**Harnett County**  
420 McKinney Pkwy  
LILLINGTON, NC 27546  
Phone:  
Fax:

**SUBJECT: BRES2407-0036**  
**BUILDING RESIDENTIAL**

Here are the results of all Inspections located at **365 BETTS RD:**

D6

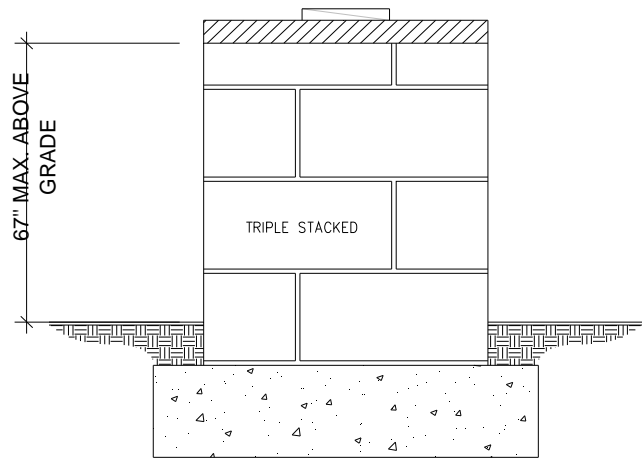
Inspection Type: FOUNDATION  
Scheduled Date/Time: 11/14/2024  
Completed Date/Time: 11/14/2024  
Inspector: Justin Ryan McLeod  
Result: DISAPPROVED  
Remarks:  
Notes: Using a probe rod the projection seems short on the only side of the pier that is covered with dirt. The pier in question will be the center most pier. Uncover footing at this area to make sure there is 2" minimum projection. Footing not passed, could not locate letter.

Inspection Type: FOUNDATION  
Scheduled Date/Time: 11/19/2024  
Completed Date/Time: 11/19/2024  
Inspector: Justin Ryan McLeod  
Result: APPROVED  
Remarks:  
Notes: Eng letter in attachments.  
Third party letter
